Our Reference: SYD19/01350/09
Departments Reference: SSD-10448

EXHIBITION OF EIS - ASPECTS INDUSTRIAL ESTATE – LOTS 54-58, DP259135 - MAMRE ROAD - KEMPS CREEK

Attachment A

**Figure 5: Construction Vehicle Routes**

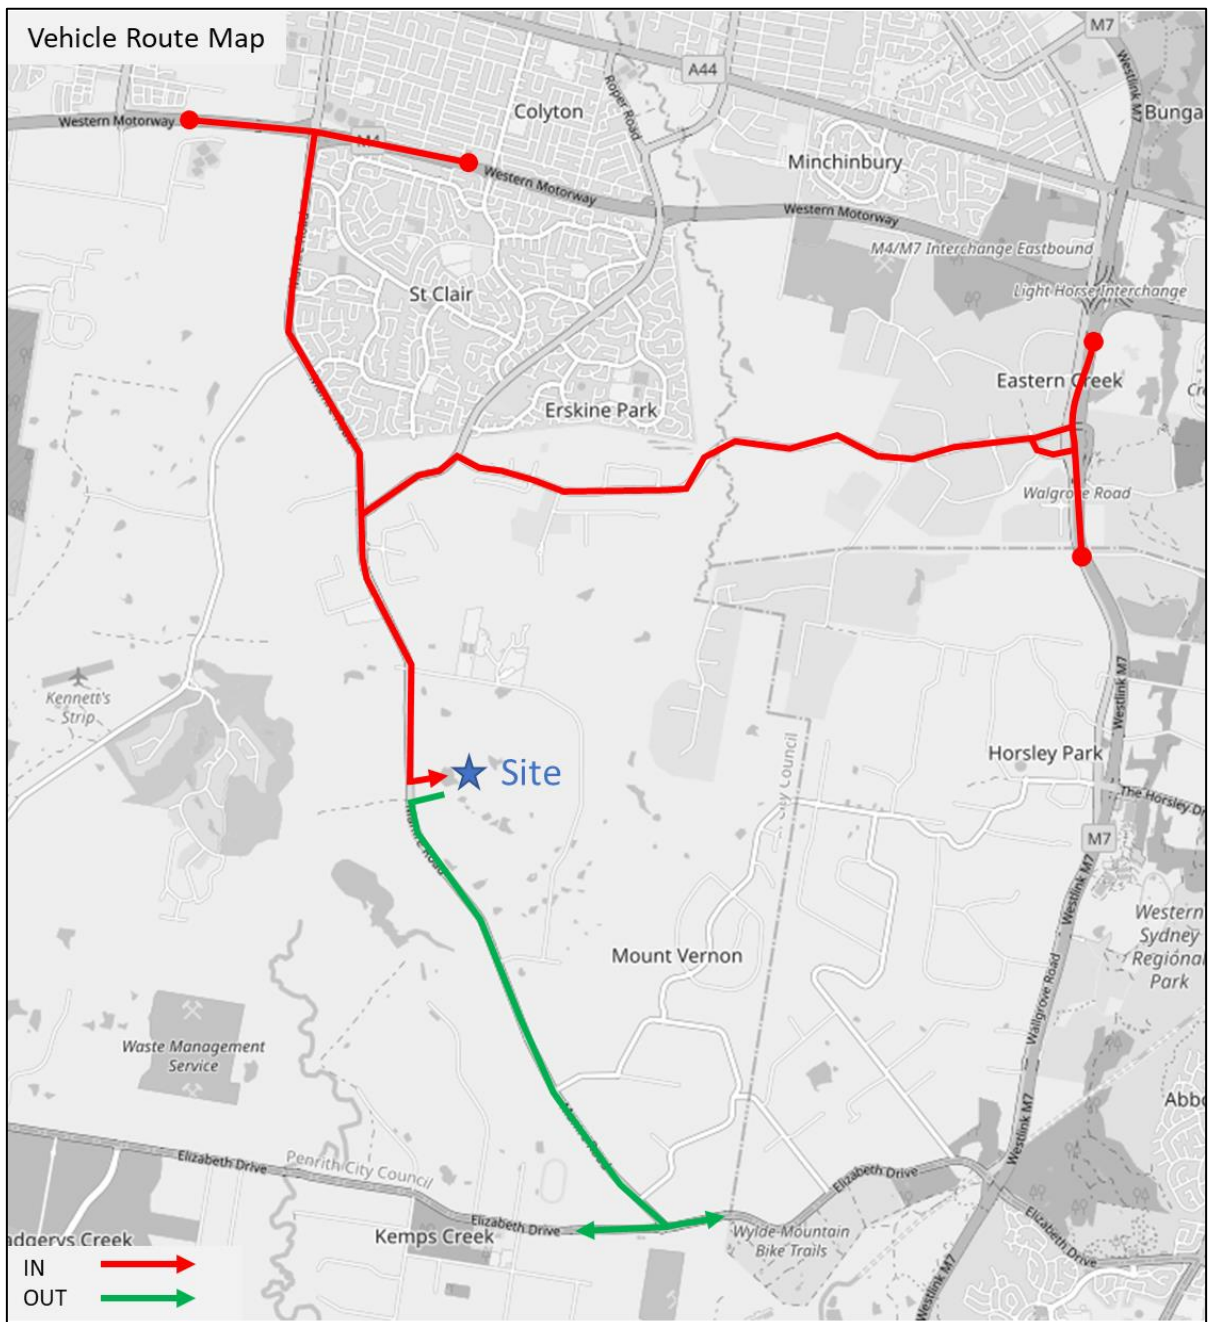
- l. Appendix B (Preliminary CTMP) – All demolition and construction vehicles are to be contained wholly within the site and vehicles must enter the site before stopping. A construction zone will not be permitted on Mamre Road.

### Swept Path Analysis

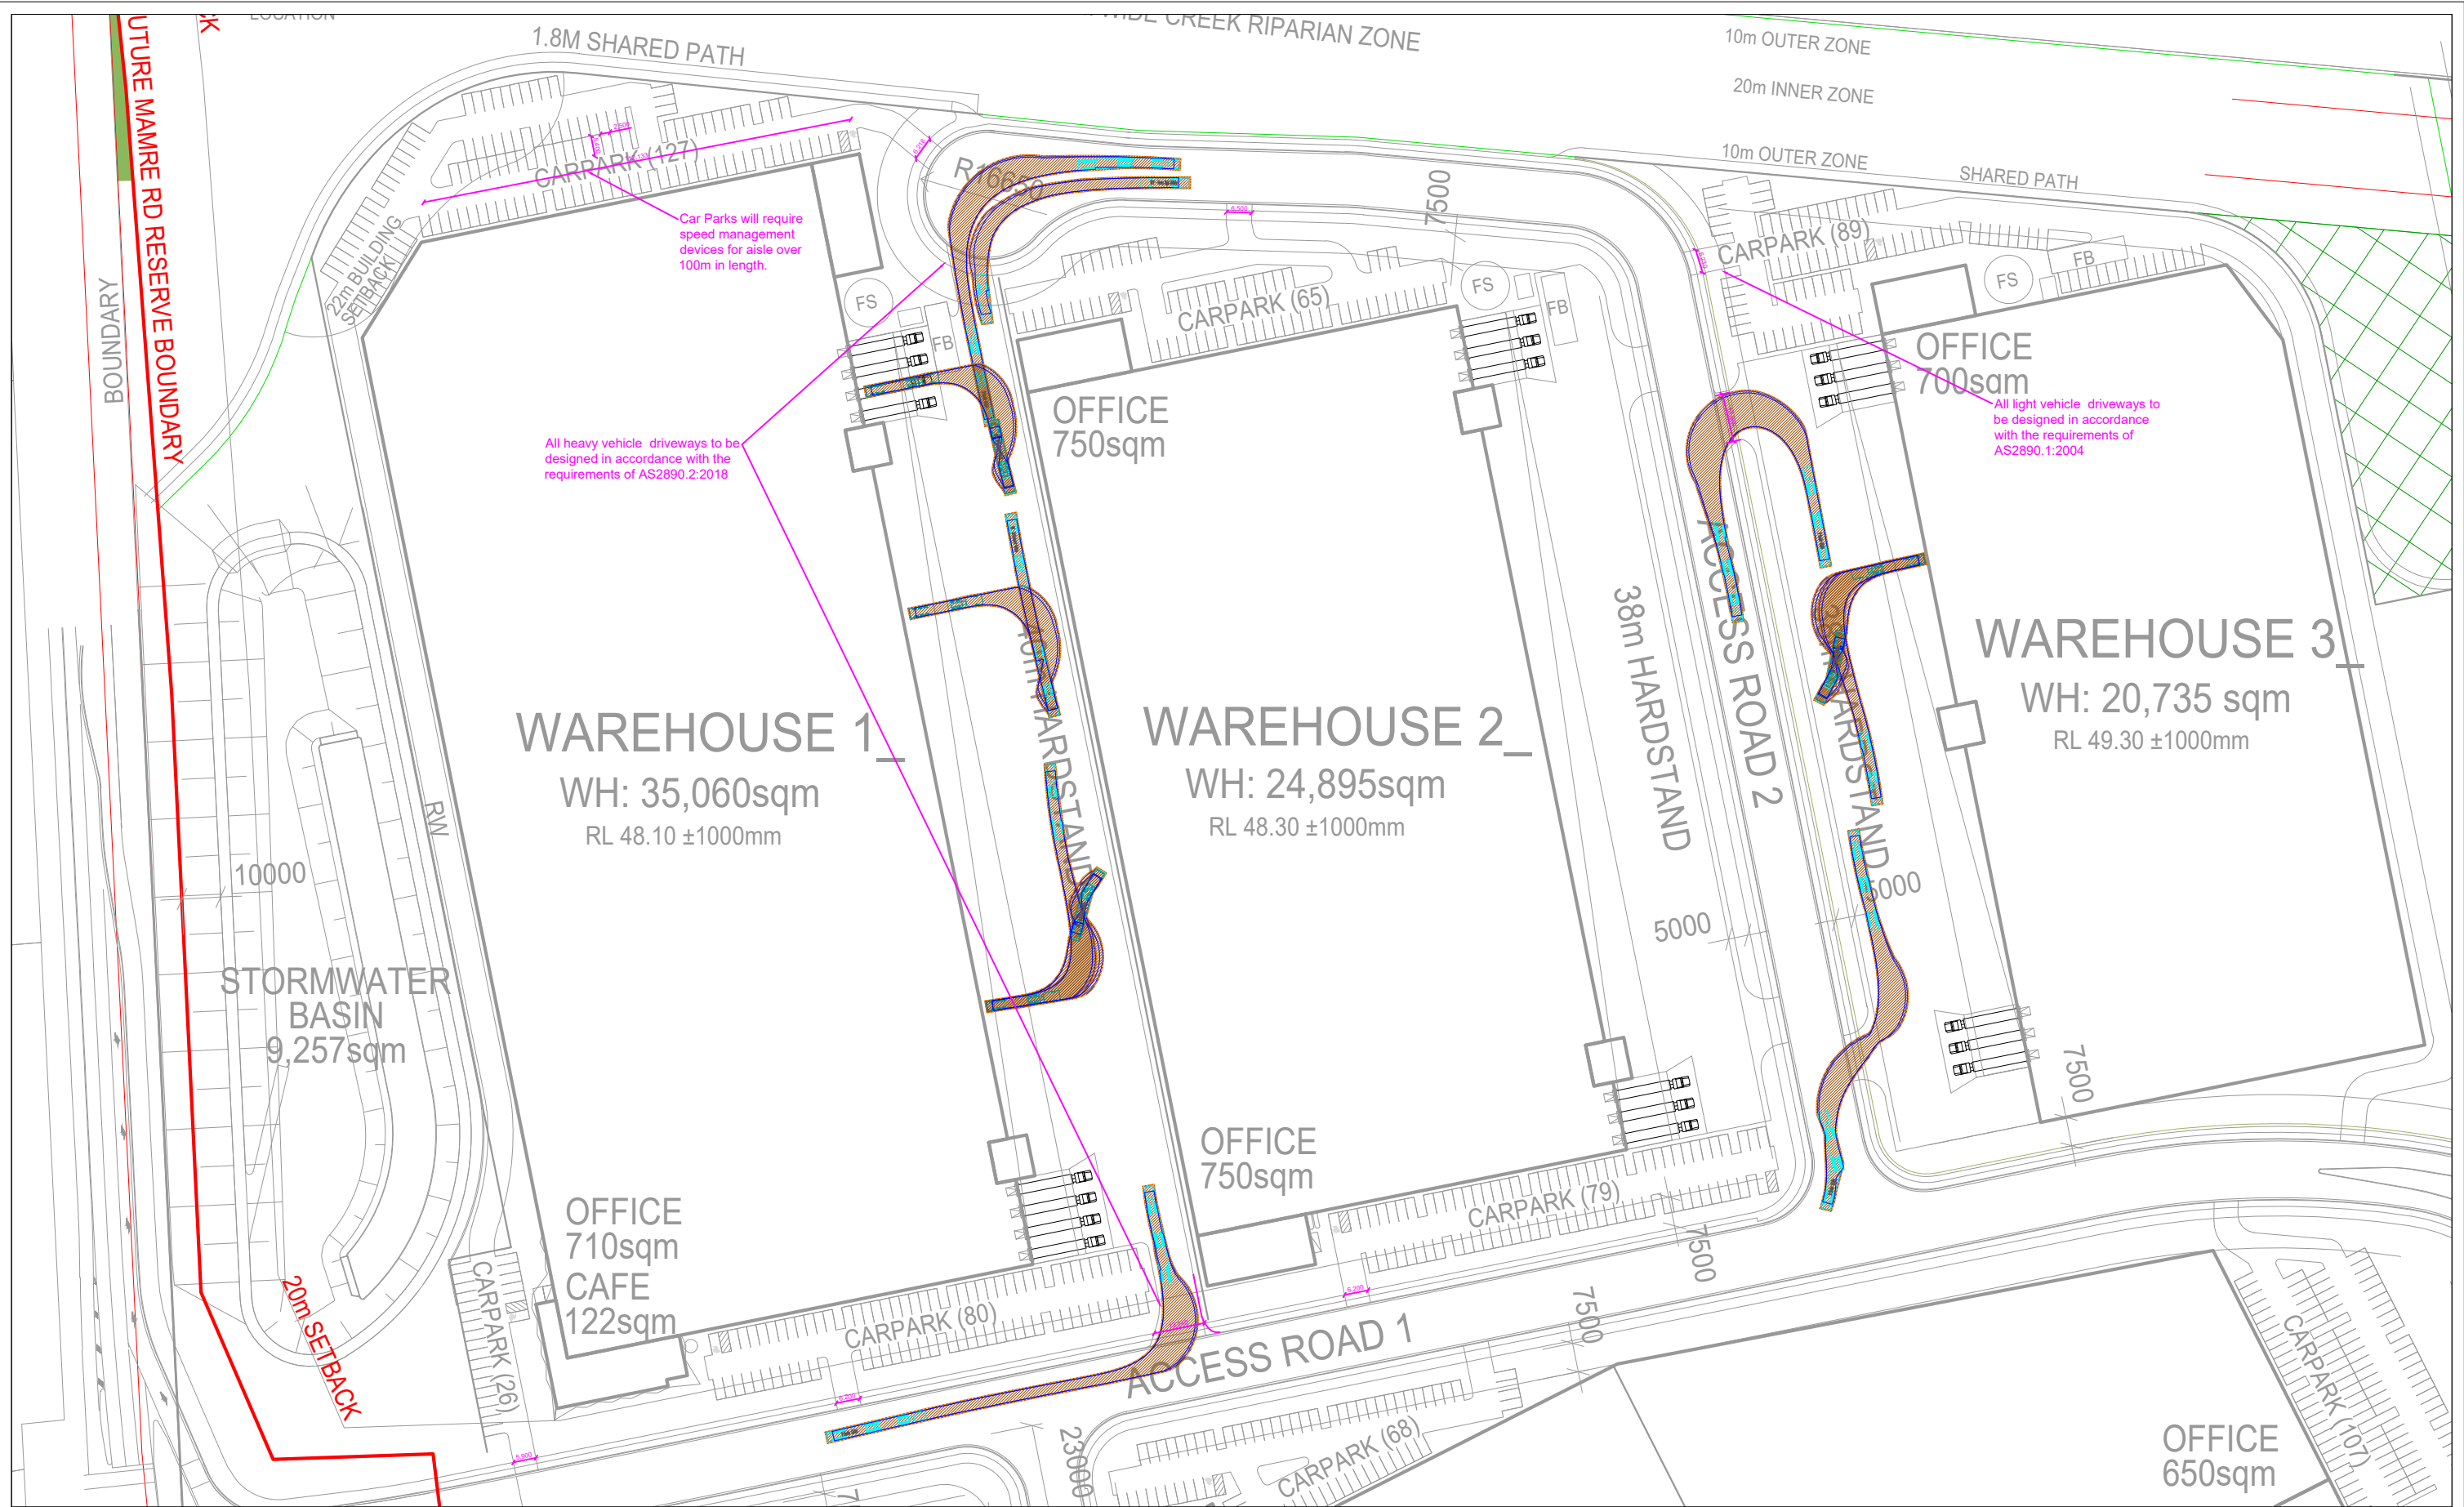
- j. Appendix F 3 – The swept paths for vehicles egressing Lot 3 on estate road 02 appears to encroach over the centreline of the road in order to achieve the turn. Consideration should be given to widening the driveway access to allow for adequate turn paths to be achieved.
- k. The swept paths provided are of a 26m B-Double. Swept paths will be required to be provided to accommodate the largest type of heavy vehicle which could reasonably be expected to service the site. The WSEA SEPP outlines the required vehicle lengths to be accommodated for.

In this regard, the design vehicle for the access to the site should be assessed with a 30m PBS 2B vehicle, in addition to the 26m B-Double.

Project	ASPECT INDUSTRIAL ESTATE MAMRE ROAD, KEMPS CREEK EXTERNAL INTERSECTION
Title	
GENERAL ARRANGEMENT PLAN

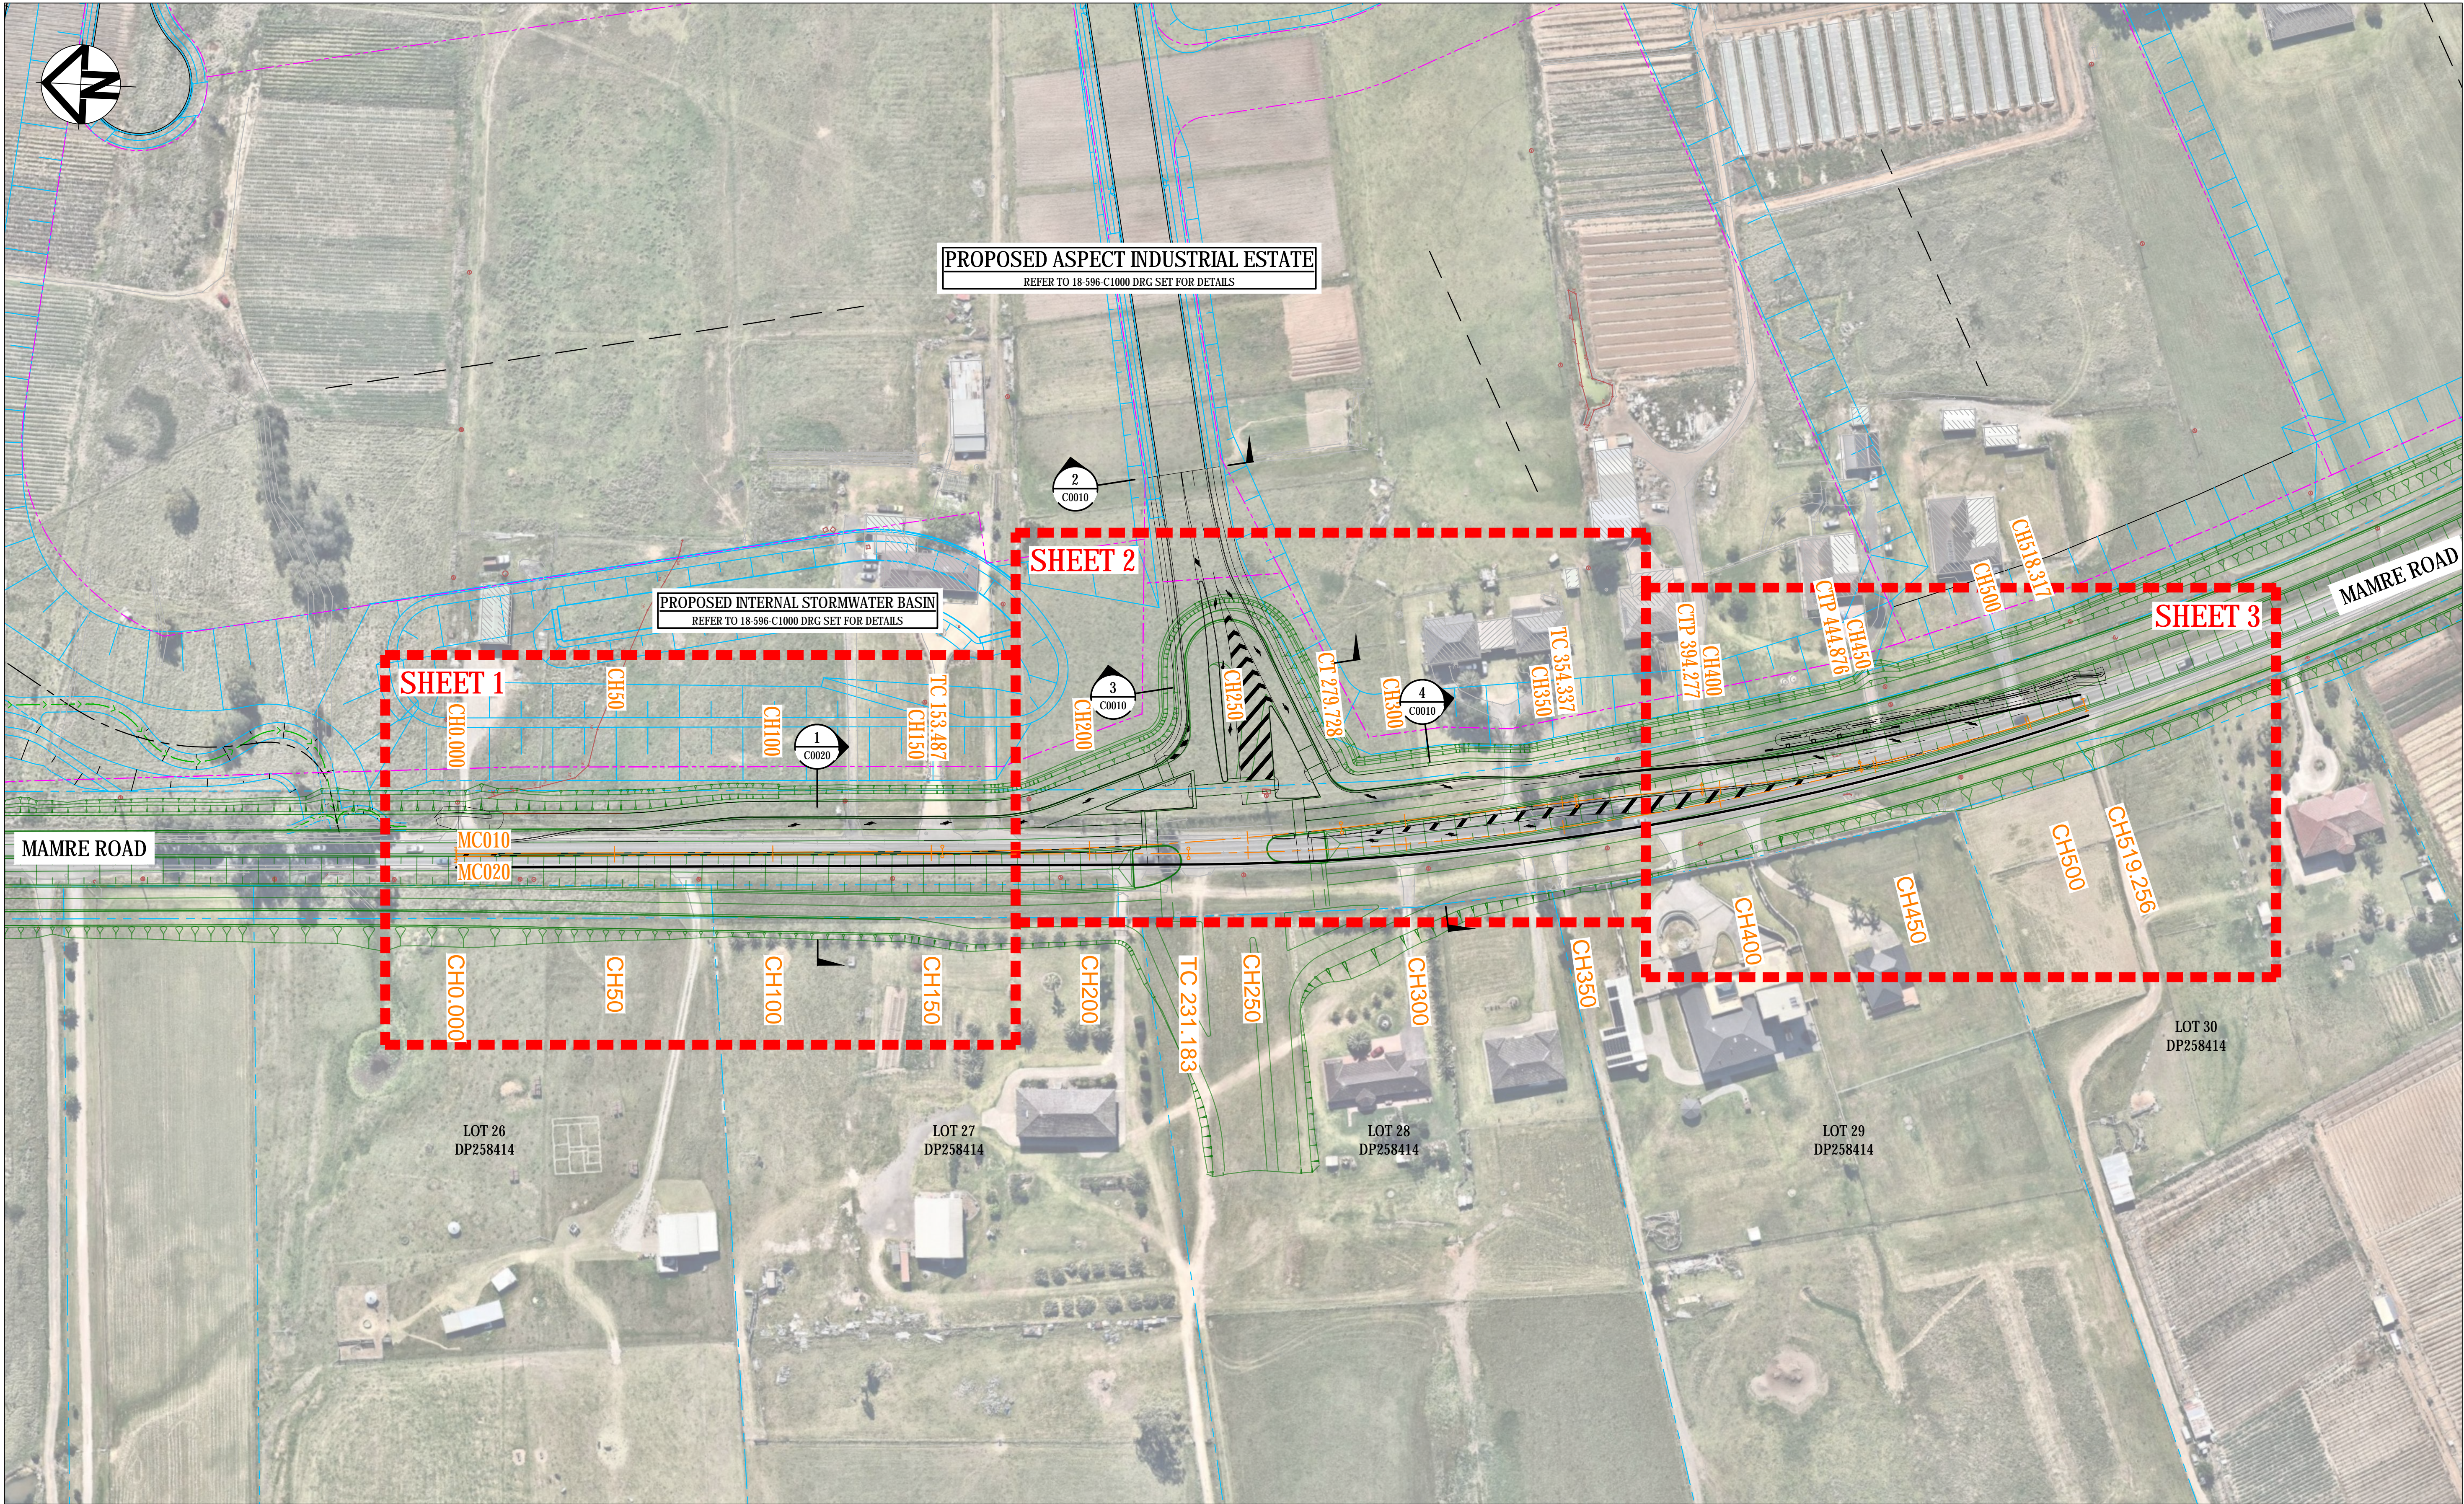
- d. The right turn bay on Mamre Road South Approach for several scenarios appears to not be adequate to store the predicted queue length.
- e. Section 7.4 – Further detail is requested to be provided to clarify how arrival and departure distribution has been adopted.

- g. Section 7.8 Figure 18 - Stage 1 2026 SIDRA Intersection Layout – Pedestrian crossings have not been provided on all legs of the proposed signalised intersection within the SIDRA modelling provided. An exemption from TfNSW is required should a pedestrian crossing not be provided on all legs.

It is therefore required that pedestrian crossings are provided on all legs and the modelling is updated to reflect this.
